Andrew M Jackson, PE  
Jackson Engineering  
11 Luther St  
Peaks Island, ME 04108

December 6, 2013

2013-00516

**Re: Barker Residence  
460 Island Avenue, Peaks Island, Maine**

SECTION AT STAIR 3

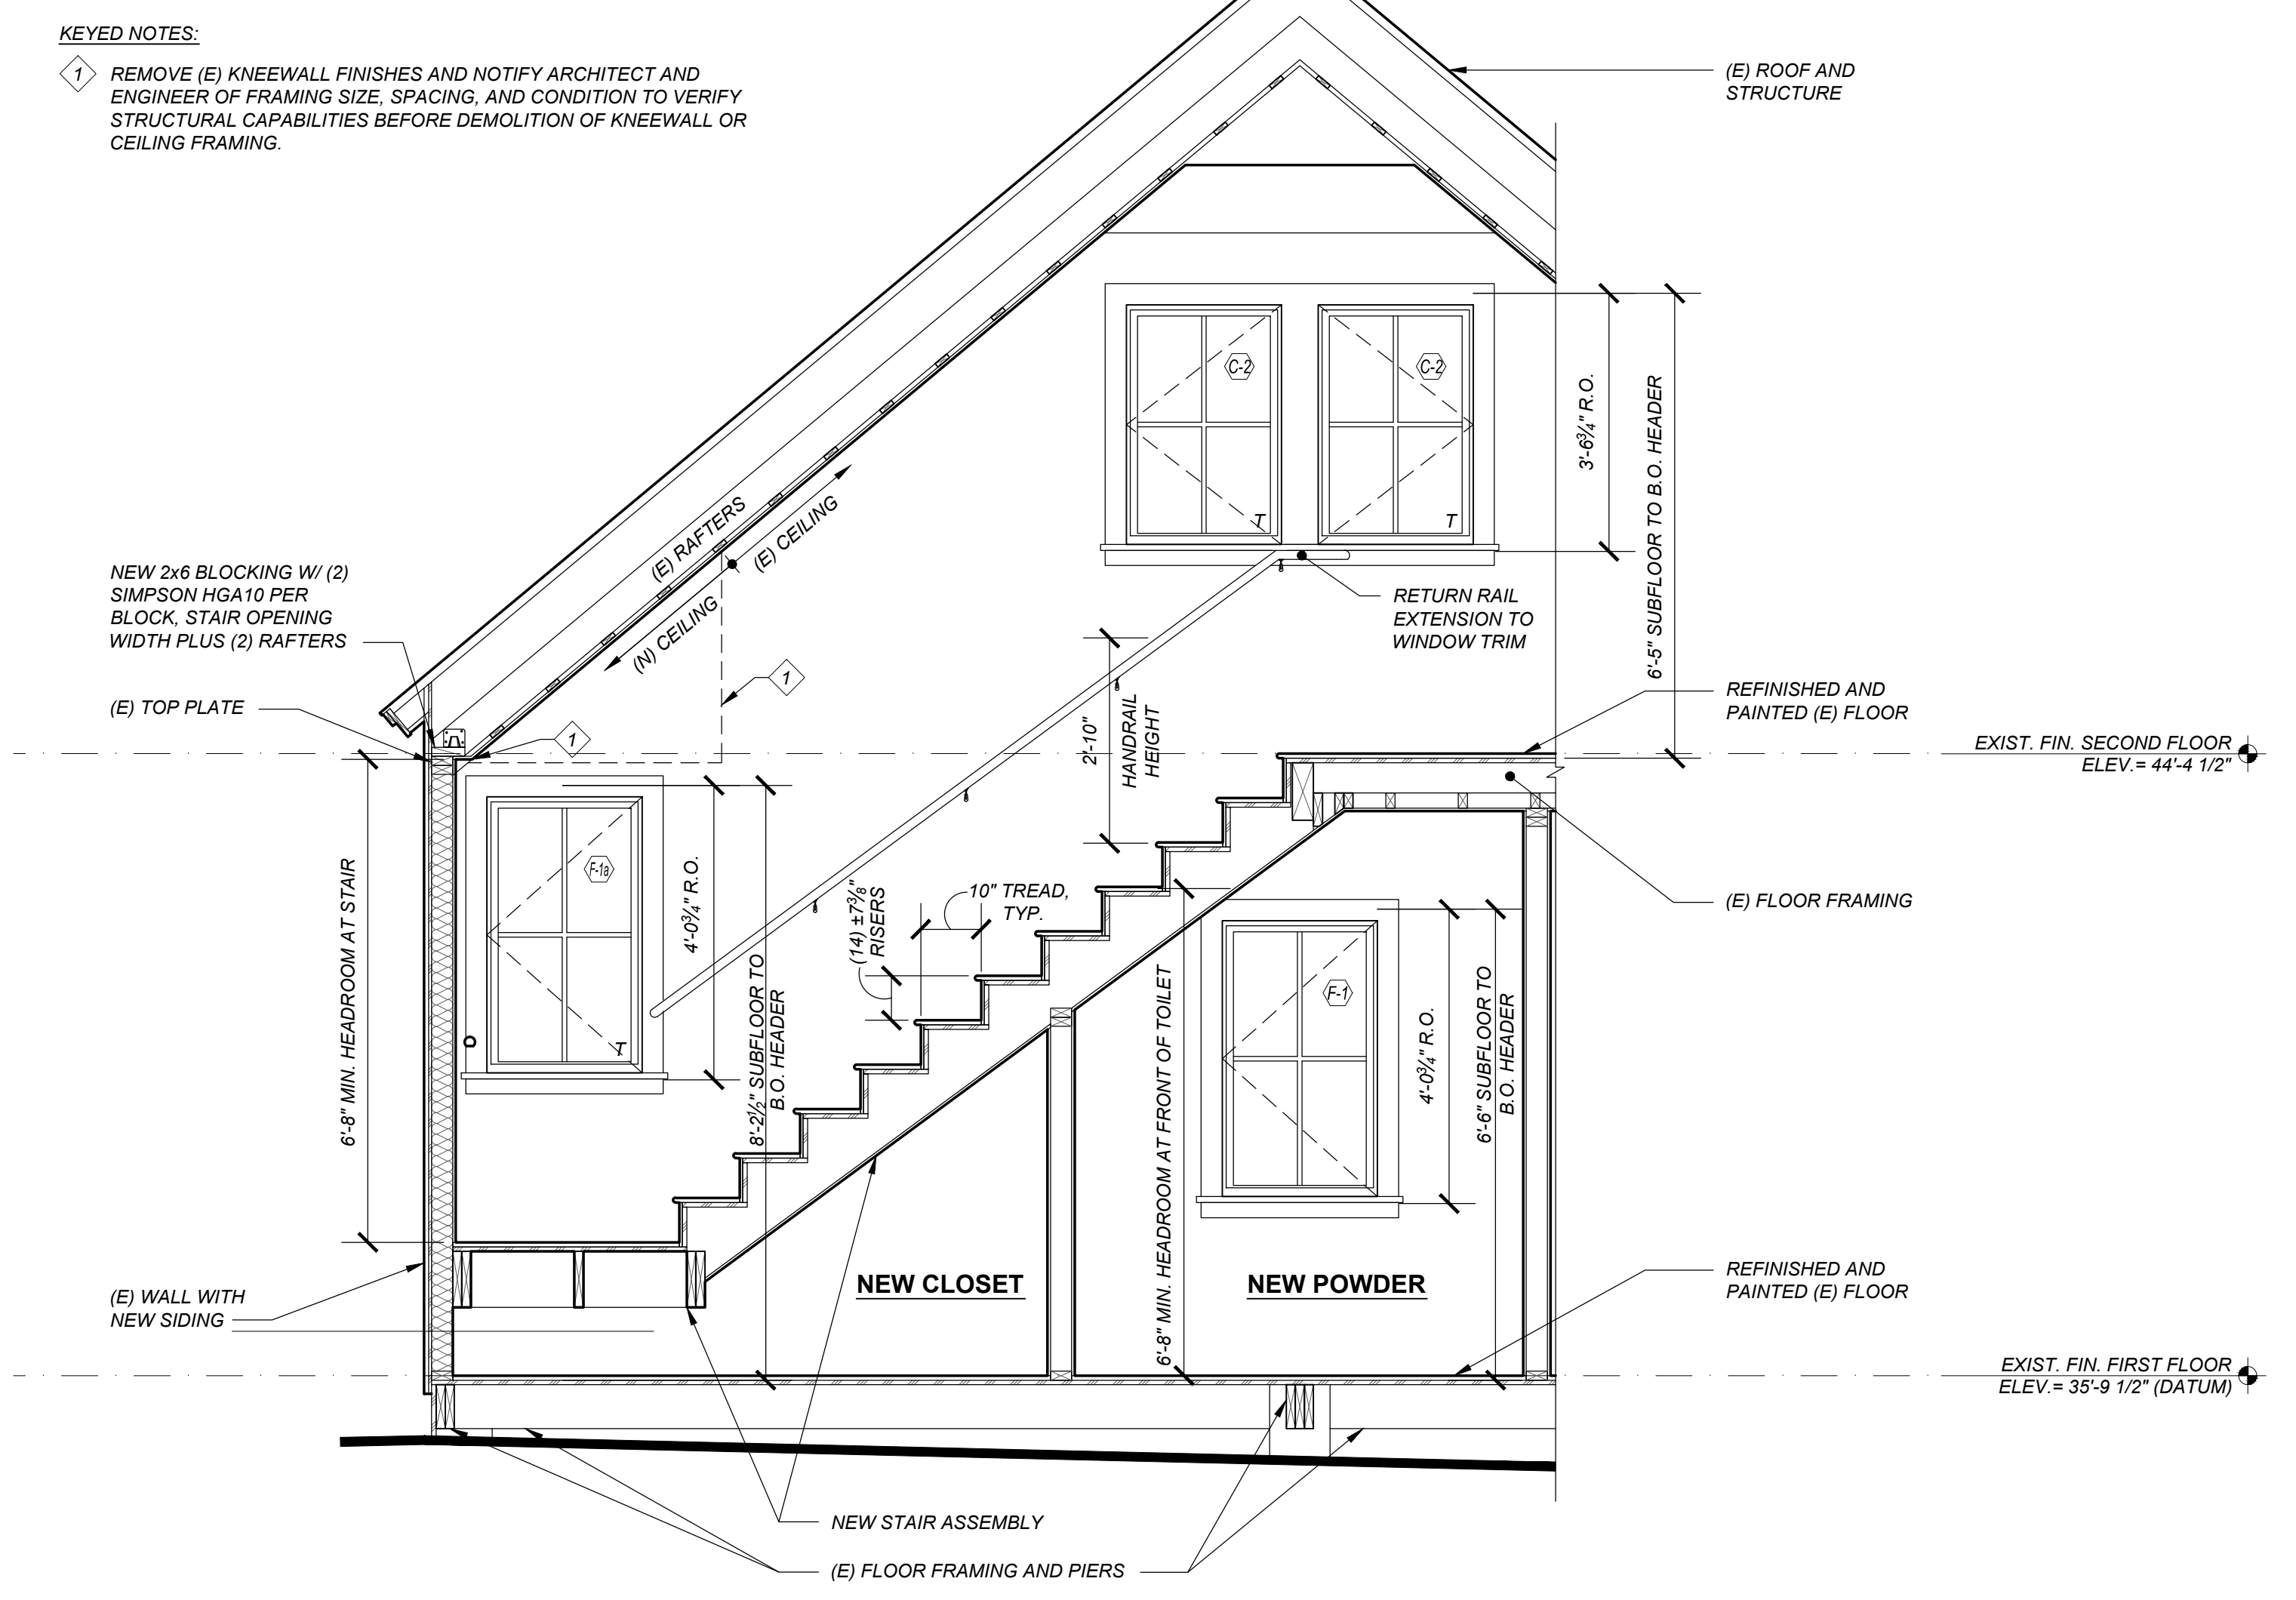
This letter refers to the structural conditions at the new stair opening in the existing residence. After revisions to framing in the field, I can confirm that the top plate detail at the enlarged stair opening is acceptable as-built provided that the adjacent ceiling joists (to the northwest of the opening) are continuously connected across the house to provide a load path to resist the gable rafter thrust. The ceiling joists can be connected with Simpson holddowns (e.g. DTTZ or larger) or tension straps (e.g., LSTI-21 or longer) or similar connection designed to resist the tie force.
